Our Ref: FG/145/19/PL

**Town & Country Planning Act 1990 (as amended)
Town and Country Planning (Development Management Procedure) (England) Order 2015
Application for Full Planning Permission**

Development Demolition of existing detached dwelling and replace with new two storey detached dwelling.
Location 31 South Drive Ferring

Replacement dwelling.
Ground & first floor plans.

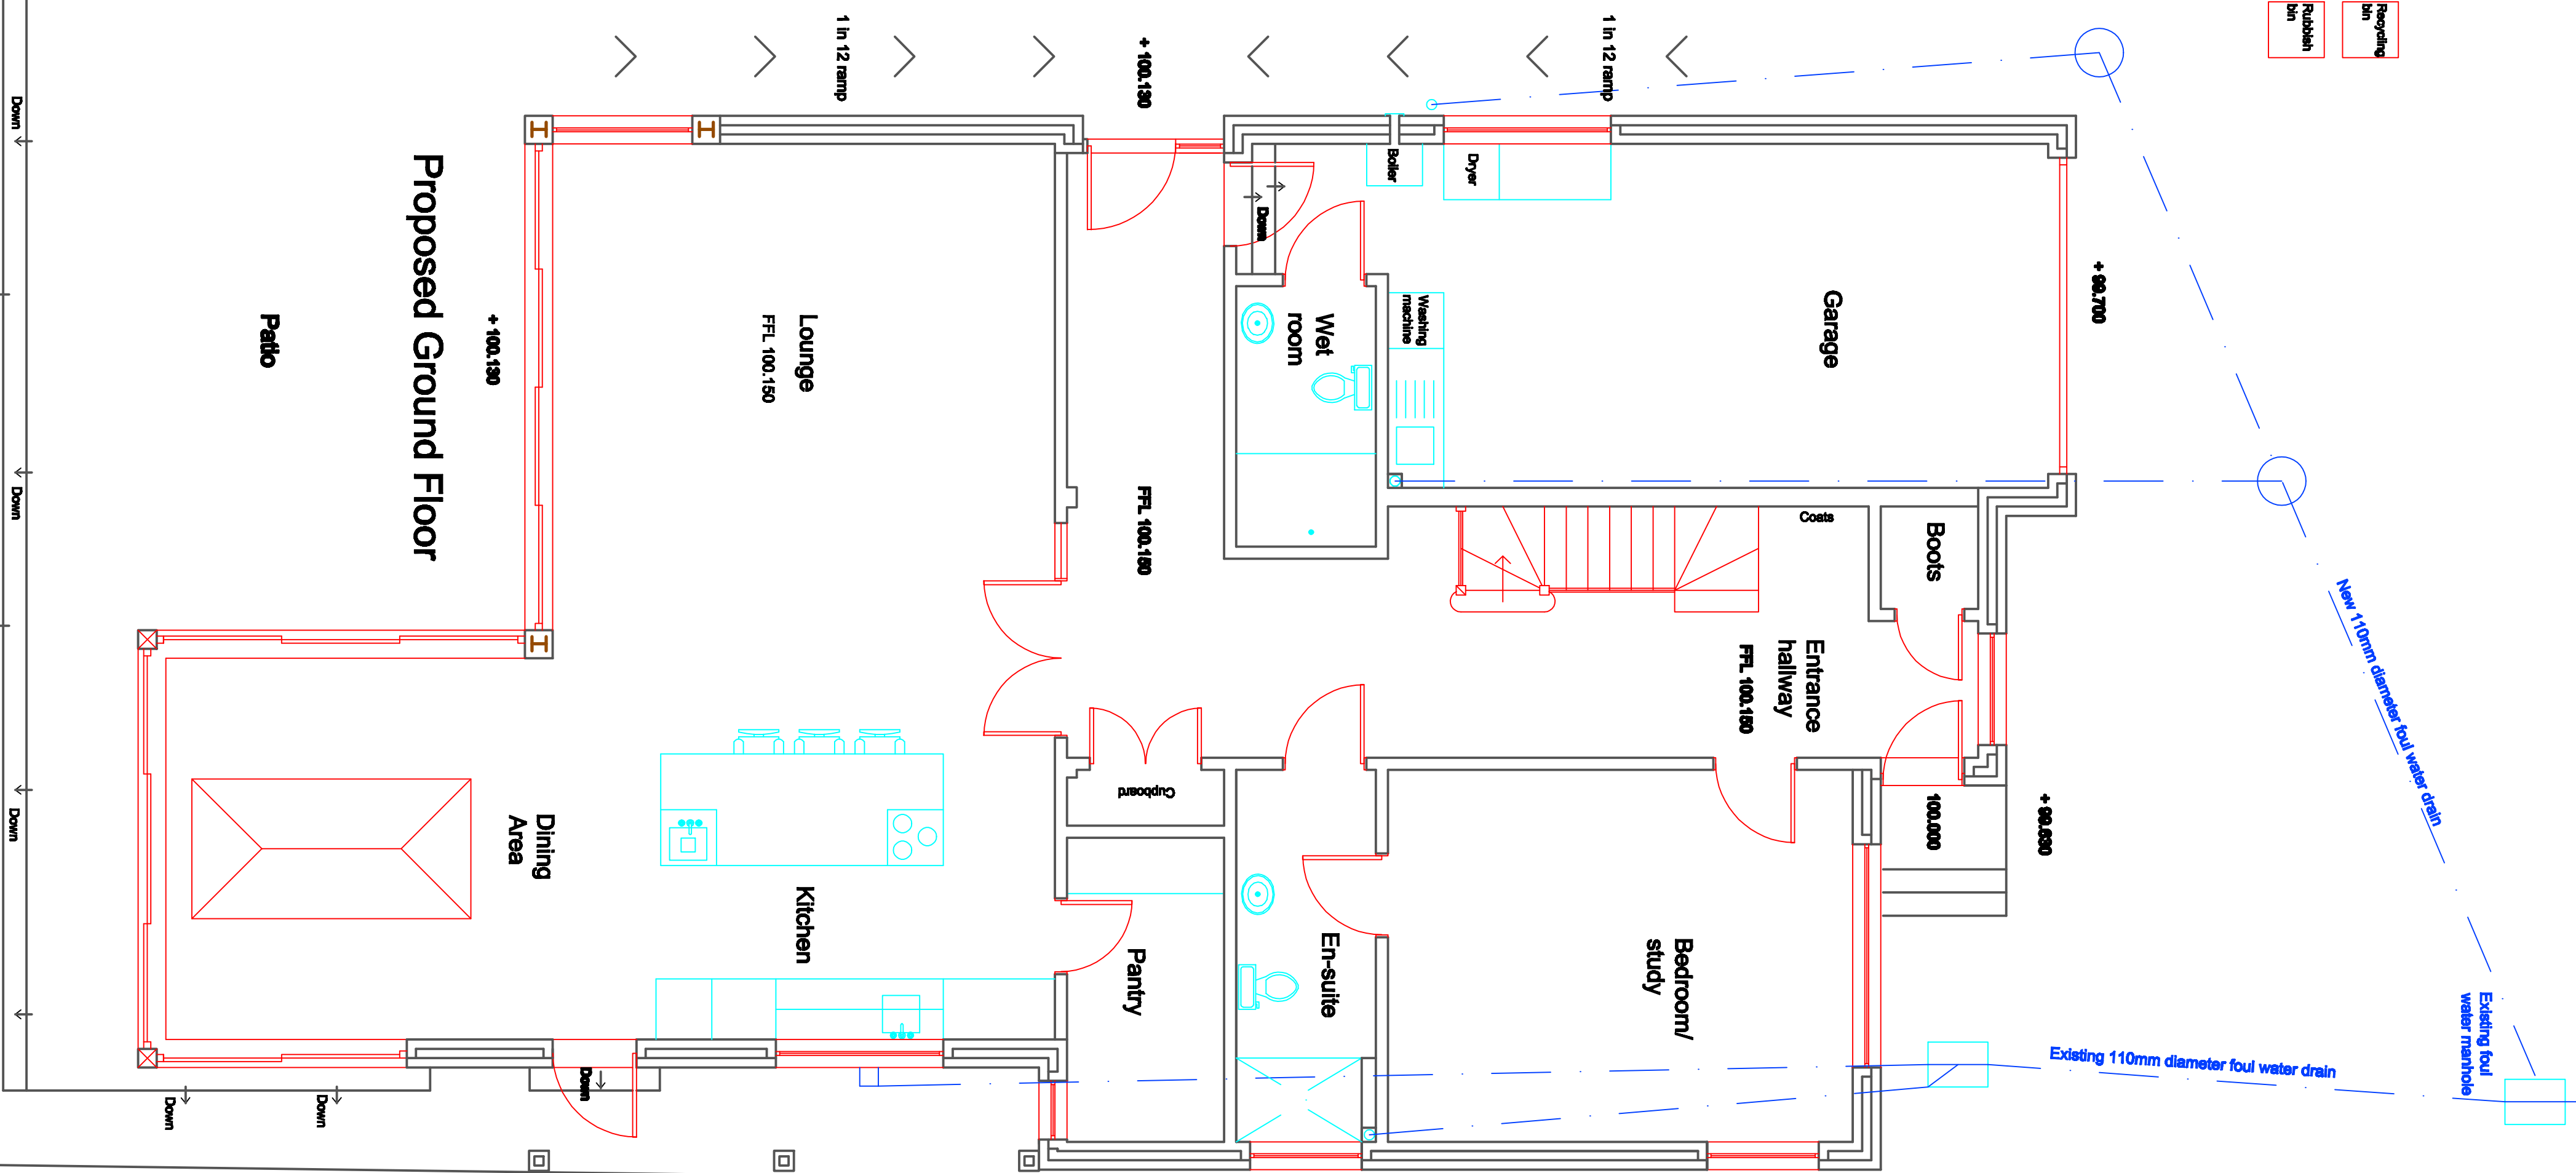
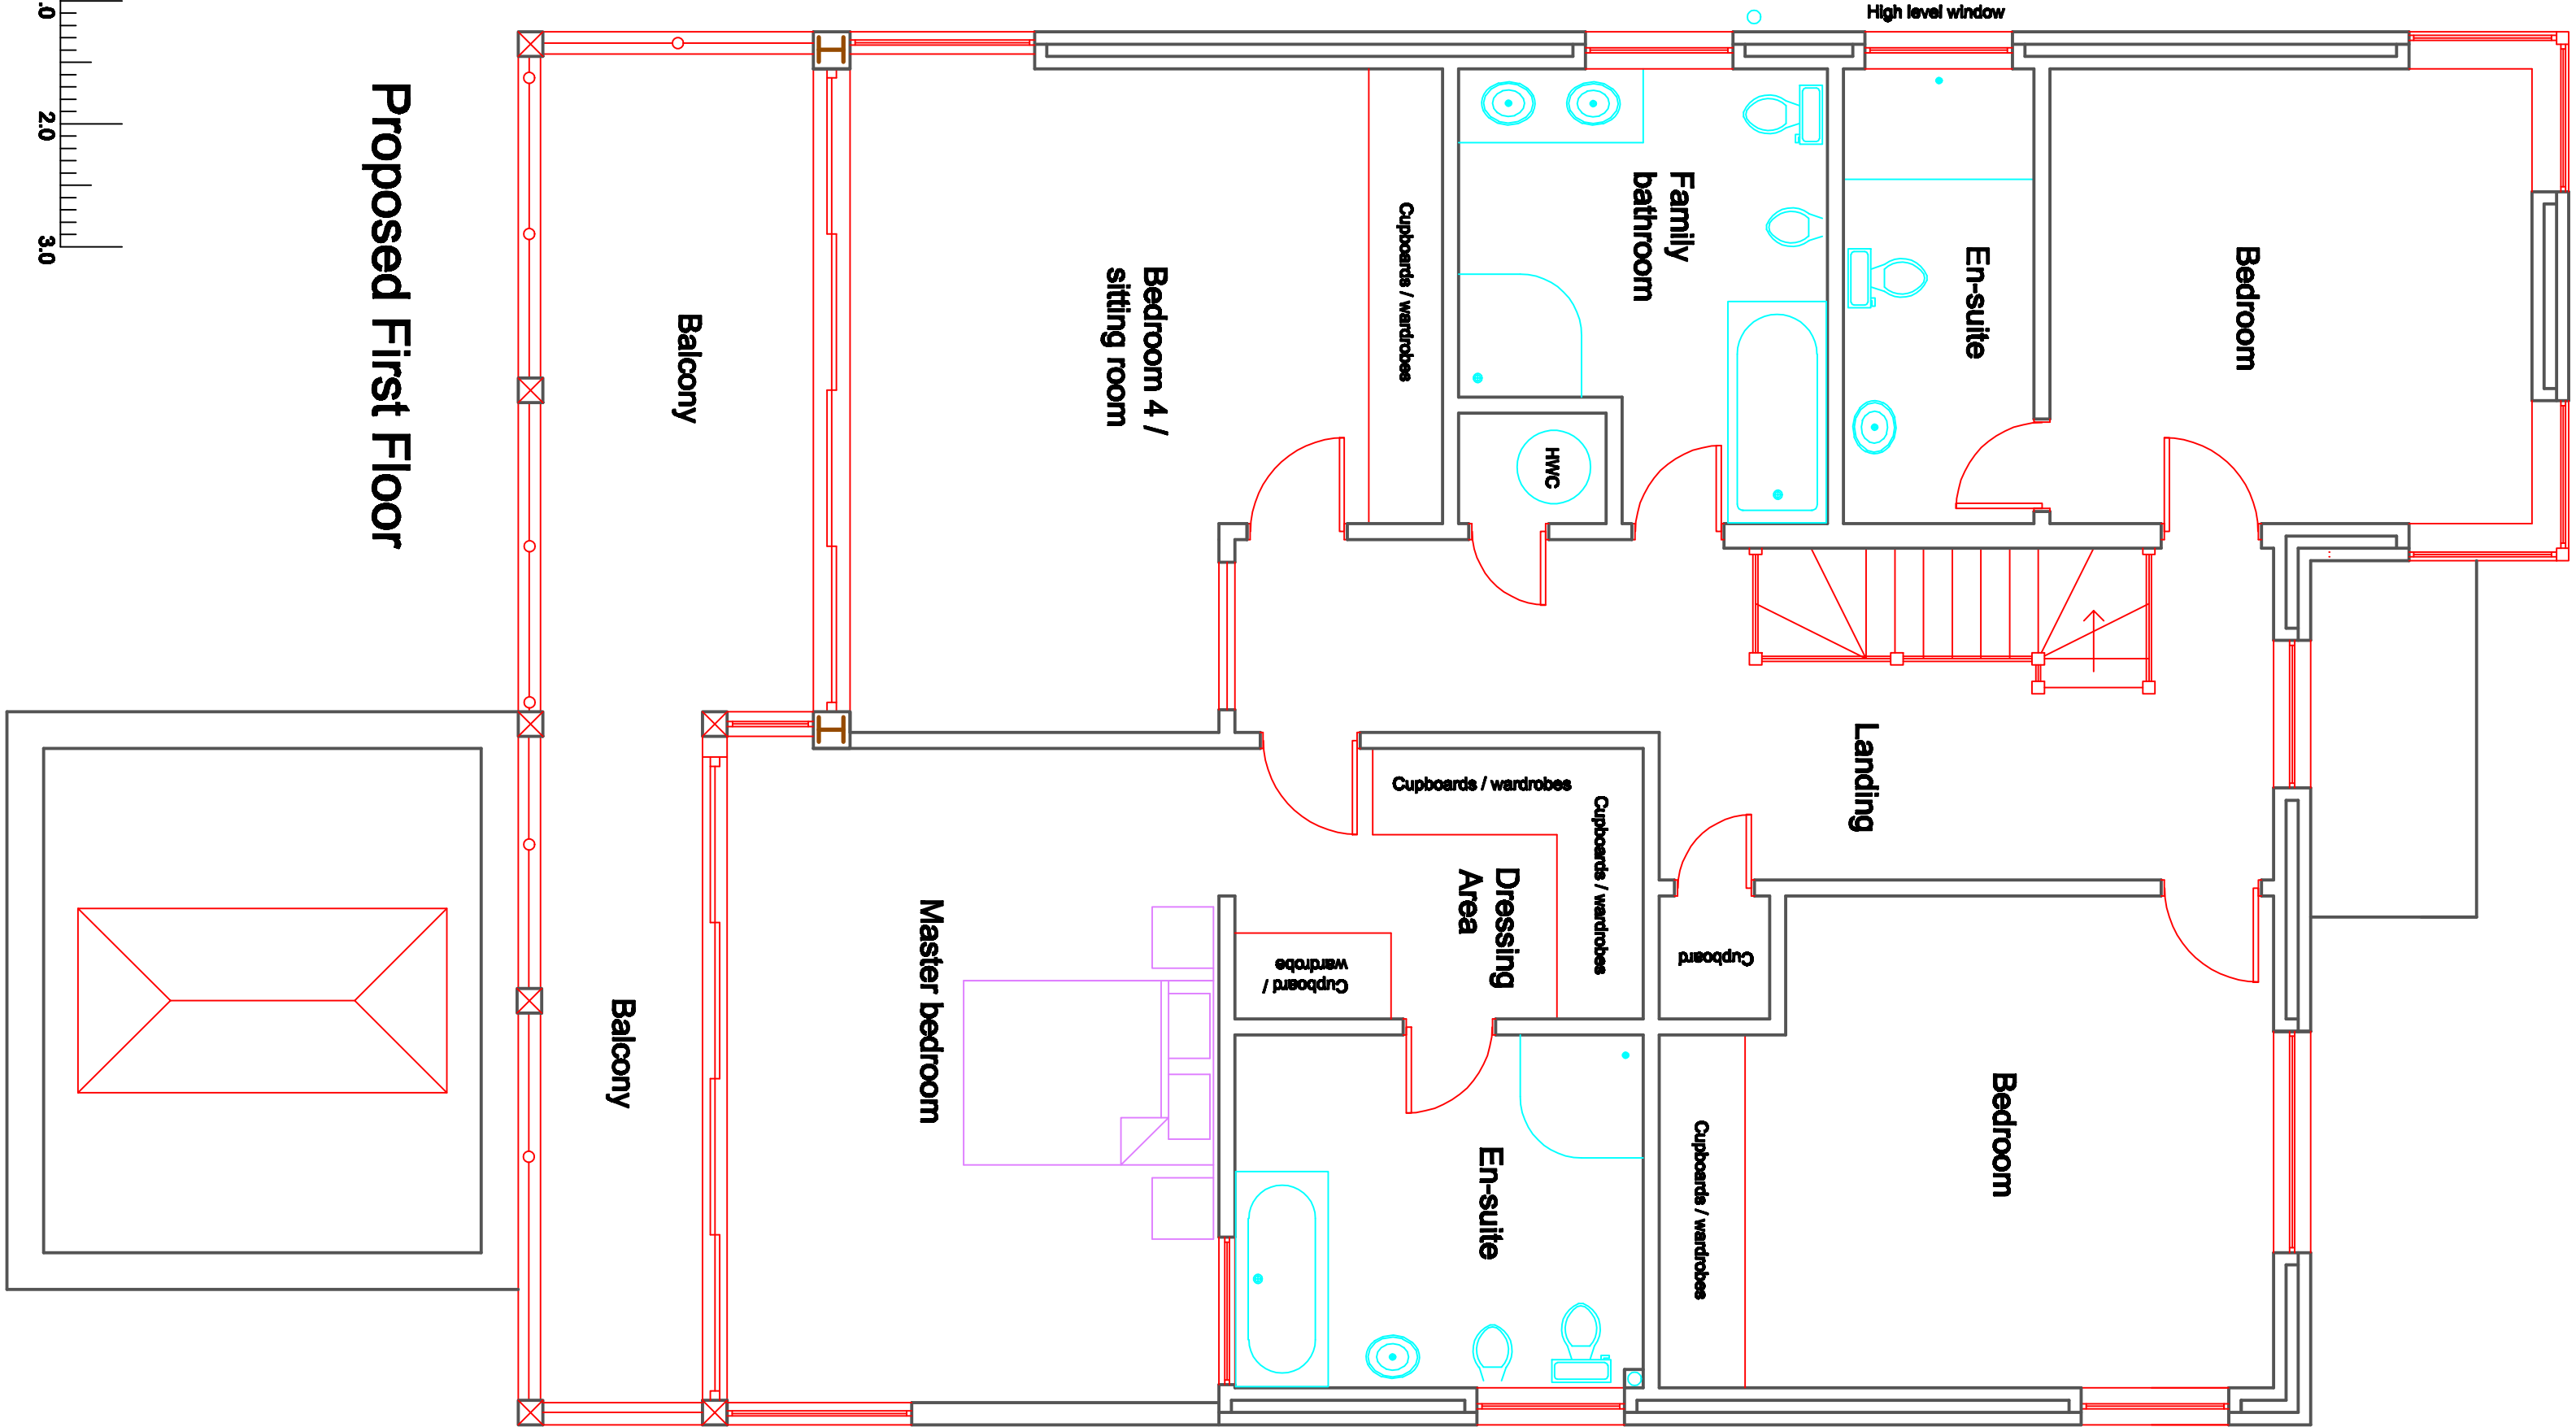
The south elevation floor and roof plan window measurements do not accord. The floor plan measurement is 1.8m and the elevation measurement is 2.4m. Please amend accordingly and resubmit.
